**Our ref:** NO/2020/112855/02-L01  
**Your ref:** 3/2020/0601  
**Date:** 11 November 2020

**OUTLINE PLANNING FOR THE CONSTRUCTION OF UP TO 125 DWELLINGS WITH PUBLIC OPEN SPACE, LANDSCAPING AND SUSTAINABLE DRAINAGE SYSTEM AND VEHICULAR ACCESS POINT FROM HIGHMOOR PARK. ALL MATTERS RESERVED EXCEPT FOR MEANS OF ACCESS.  
LAND AT HIGHMOOR FARM, CLITHEROE, BB7 1PN**

We have reviewed the submitted FRA produced by Topping Engineers, reference 18522, dated August 2019.

Drawing title: Flow Exceedance Plan

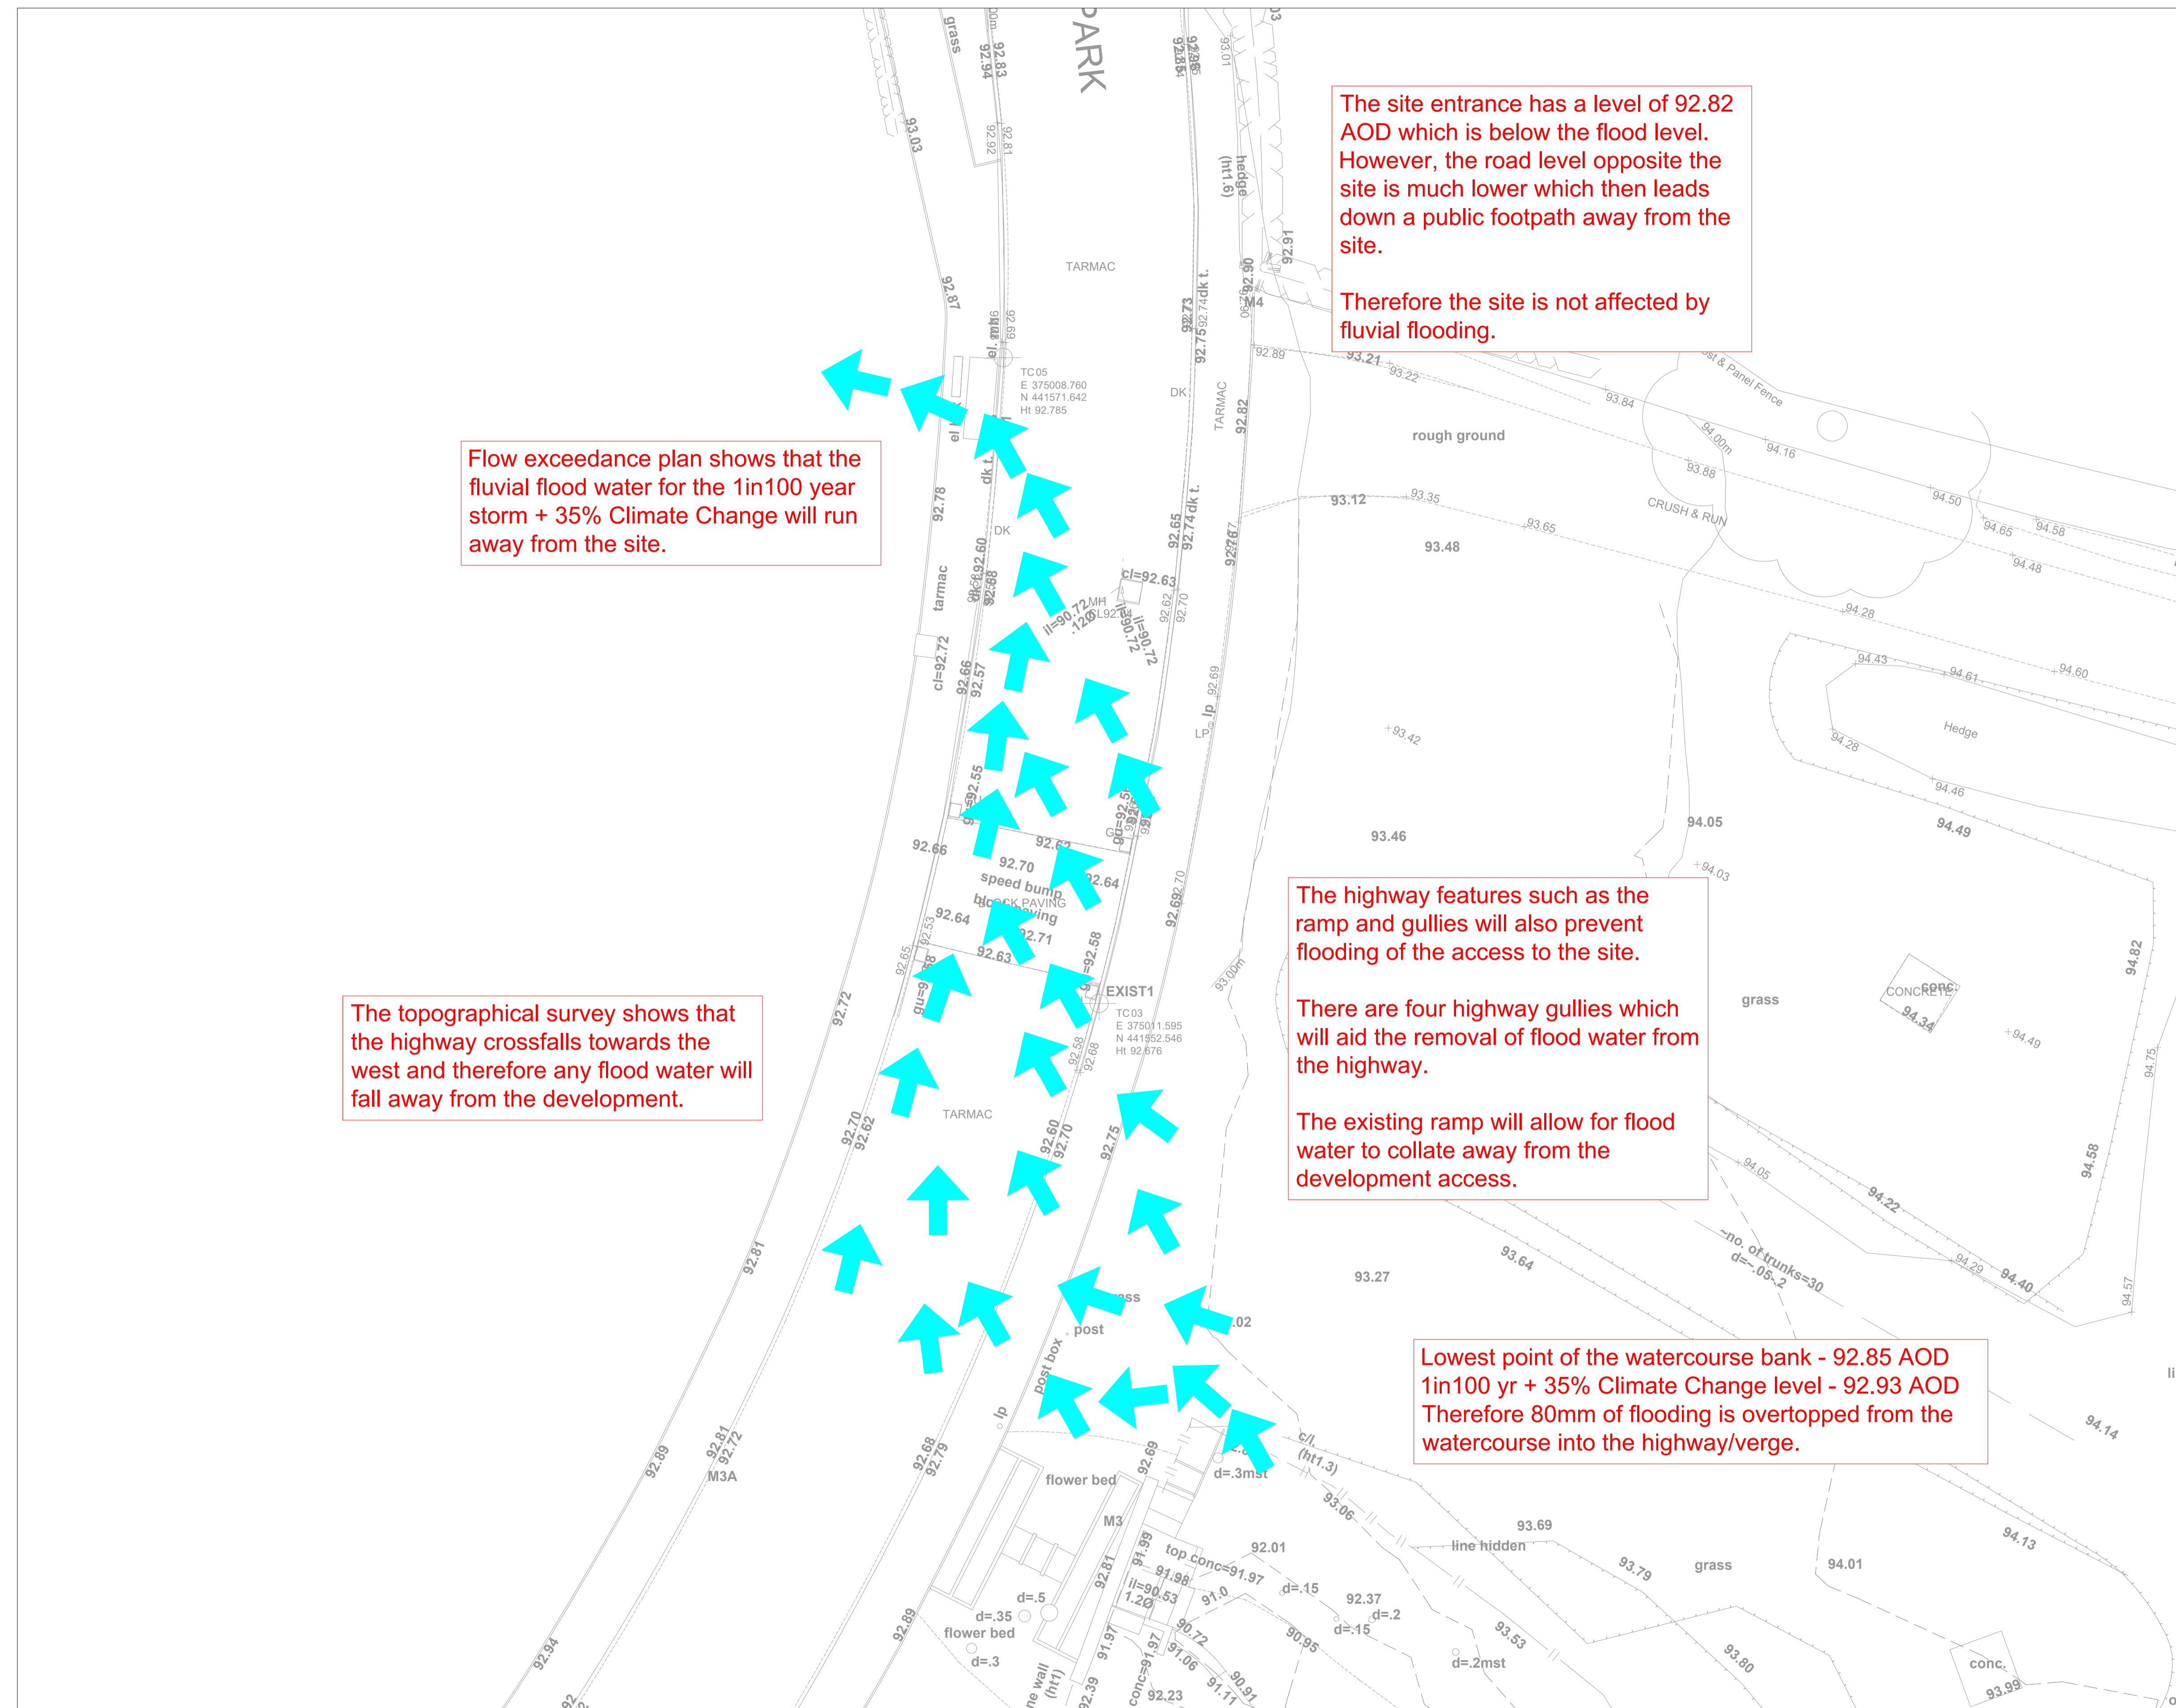
The revised FRA has assessed the 30% climate change allowance to Shaw Brook, Main River, however this allowance does not comply with those advised in '[Flood risk assessments: climate change allowances](#)' and its use has not been justified. The area of the site off Highmoor Park road is located partially in and adjacent to the flood zone. As a result of this, areas of the site may be located in the future flood zone 3 and the impact of future climate change on the risk of flooding must be assessed further.

- take the impacts of climate change into account at the access point to the site.
  - Different climate change allowances have been used to assess future flood risk than those advised in '[Flood risk assessments: climate change allowances](#)', without adequate justification. As a result, there may be inadequate safe access and egress routes to the site as the flood risk for the lifetime of the development has not been assessed.

To overcome our objection, the applicant should submit a revised FRA which assesses the impact of climate change in line with the recommended climate change allowances on flood risk at the access point to the site over the life time of the development.
